# **OXFORDSHIRE COUNTY COUNCIL'S RESPONSE TO CONSULTATION ON THE FOLLOWING DEVELOPMENT PROPOSAL**

**Application no:** 16/01805/F-2

**Proposal:** Change of use of buildings from sui generis MOD use to various commercial uses as detailed in accompanying Planning Statement with associated physical works and demolition of buildings 101 and 104 and erection of replacement structures.

**Location:** Bicester Heritage Buckingham Road Bicester OX26 5HA

Figure 1: Bus stops indicated in red at site entrance

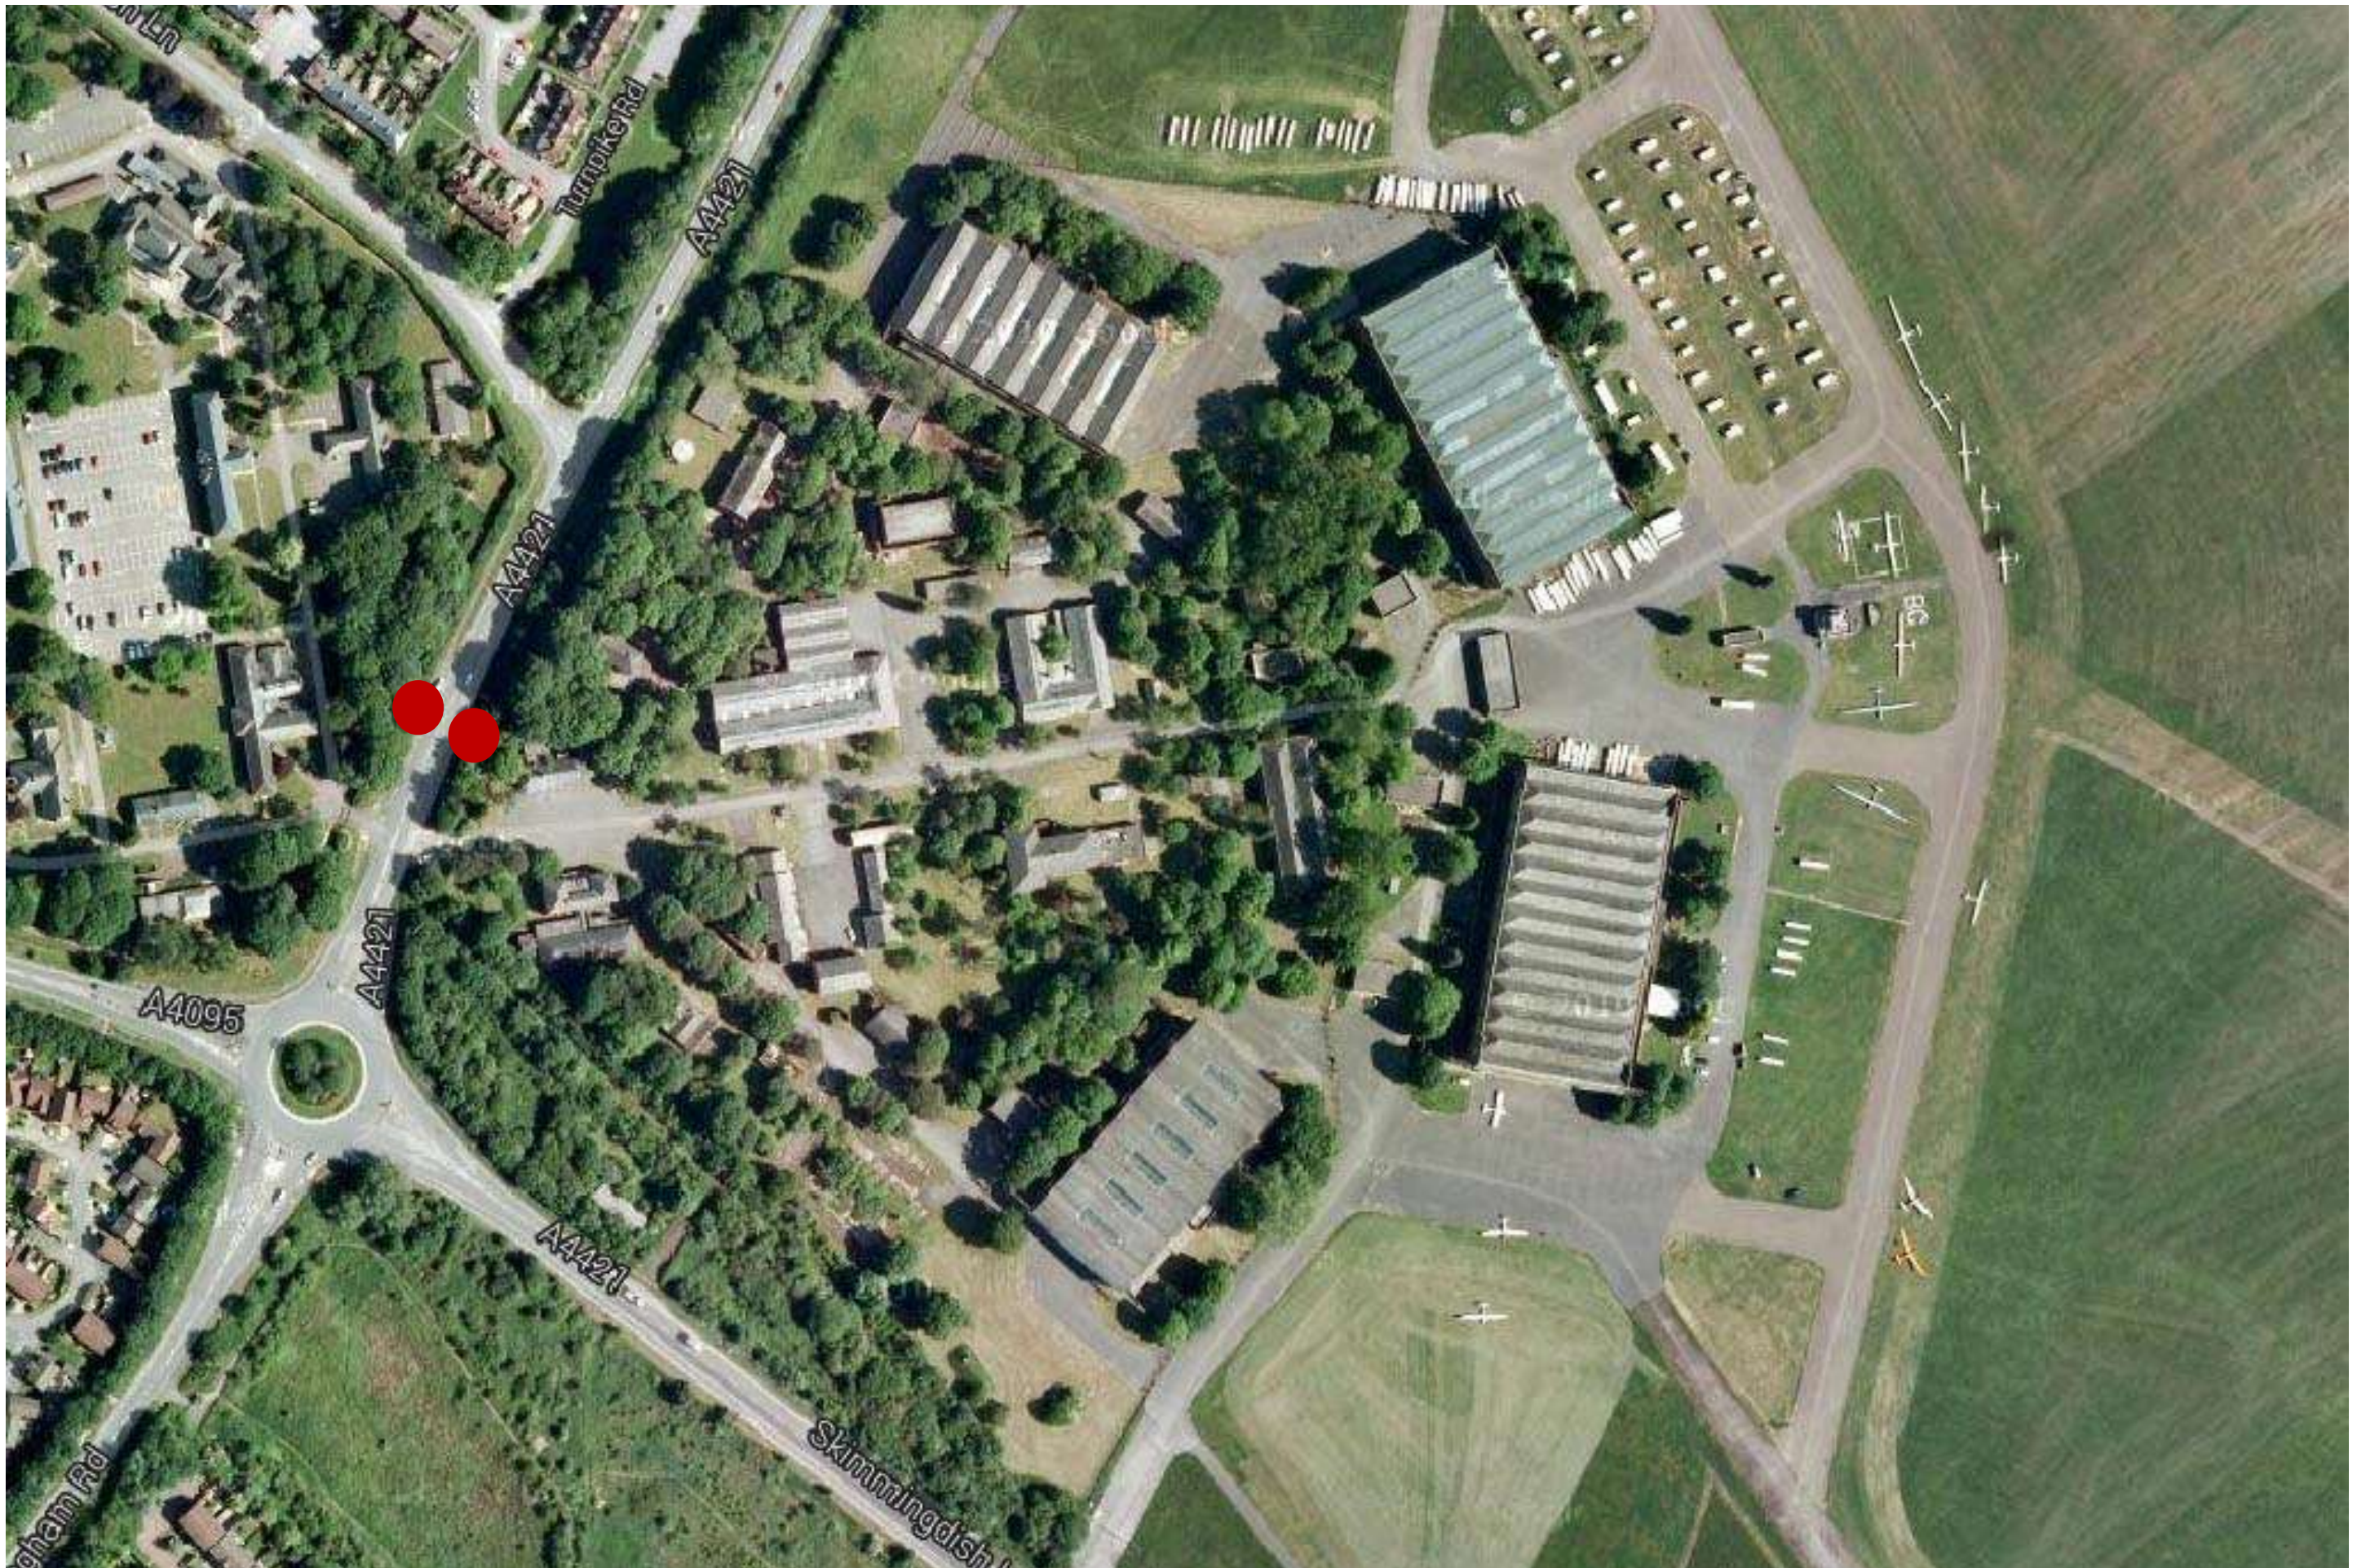
- The applicant has not demonstrated safe and suitable access for all. Whilst there are reasonable pedestrian and cycling facilities in the vicinity of the development, there is no safe and convenient way for people to get to them from the main access of the development on the Buckingham Road. Pedestrians cannot conveniently and safely get to and from the nearby pair of bus stops on the Buckingham Road. A crossing of Buckingham Road will need to be provided.

The provision of a crossing of Buckingham Road would double up as a way for people travelling to the site by bus to do so safely. Together with this crossing, a footway leading to/from the southbound bus stop will ensure that using the bus to get to and from this development becomes not just a safer but also a much more attractive proposition – very much more in line with the intentions of the NPPF, specifically paragraphs 32 and 35.

To further improve the attractiveness of travelling by bus to/from this site, the applicant will be required to provide funding for an additional enhancement to the public transport infrastructure – £10,102 towards a solar powered real time information display for the southbound bus stop (there is no mains electricity in the vicinity of the site).

If Cherwell District Council is minded to grant planning permission, a S278 would be needed to provide an improved site access to include pedestrian provision at the access itself and also to ensure pedestrians and cyclists can access the nearby footways, cycleways and bus stops i.e. footway extension/improvements and a crossing of Buckingham Road.
